From: Jack Dowling <[REDACTED]>
Sent: 04 September 2025 12:00
To: Iqraa Malik
Subject: RE: Request for further information Y/53/25/HH
Attachments: Proposed Elevations.pdf; Proposed Floor Plans.pdf; Existing Elevations.pdf; Existing Floor Plans.pdf

Subject: Request for further information Y/53/25/HH

Existing North Elevation

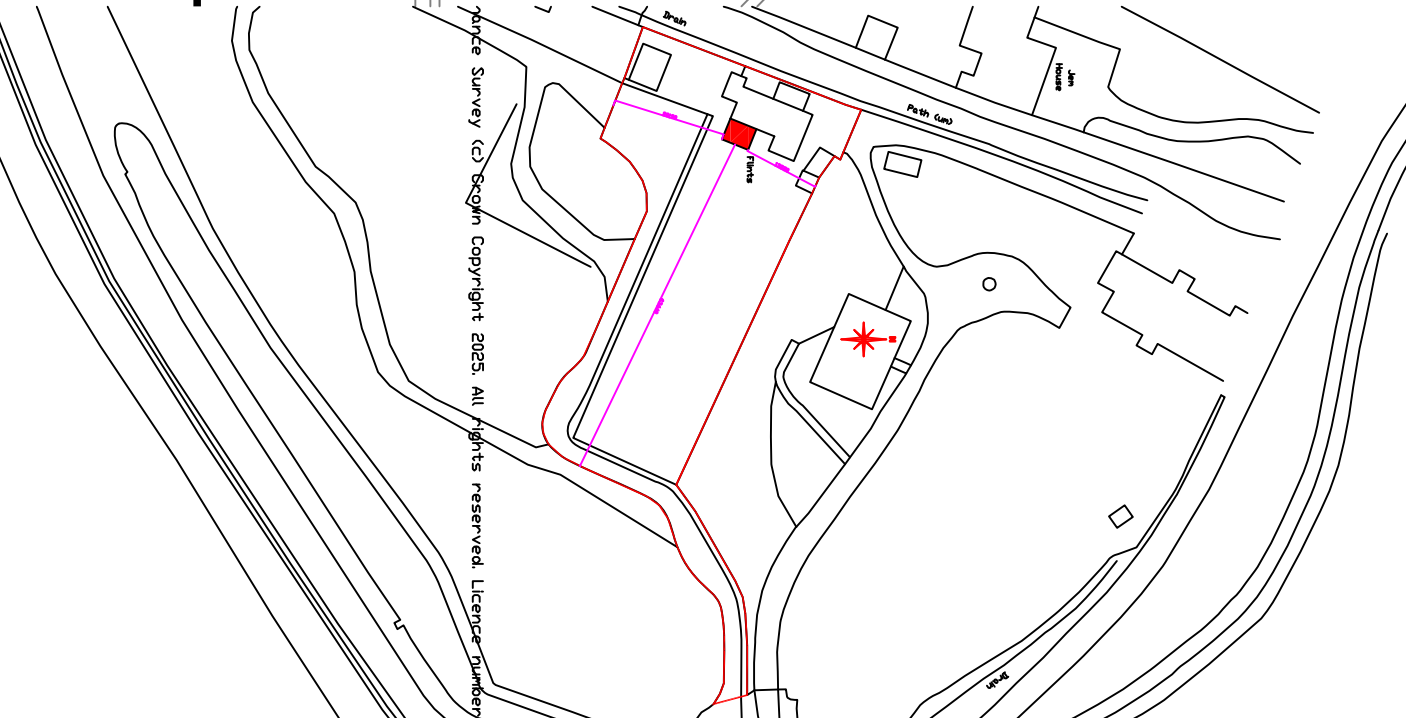
The building lines shown on the north elevations are inconsistent with the floor plans. In addition to this, the proposed extension isn't shown on the proposed north elevation, please review and amend accordingly.

Proposed North Elevation

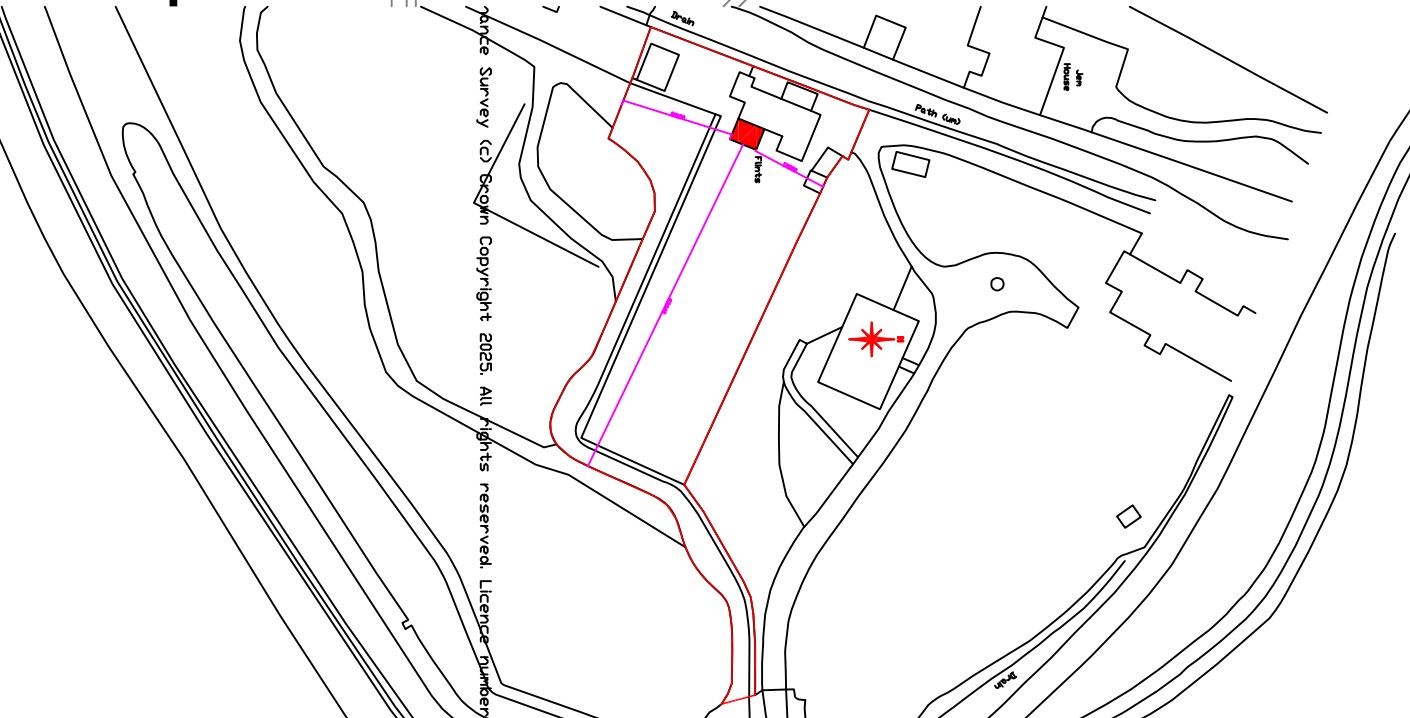
Unfortunately, this application is still invalid as the dimensions listed on the block plan are unclear, please review and amend. In addition to this, the north elevations are still inconsistent with the ground/first floor plans.
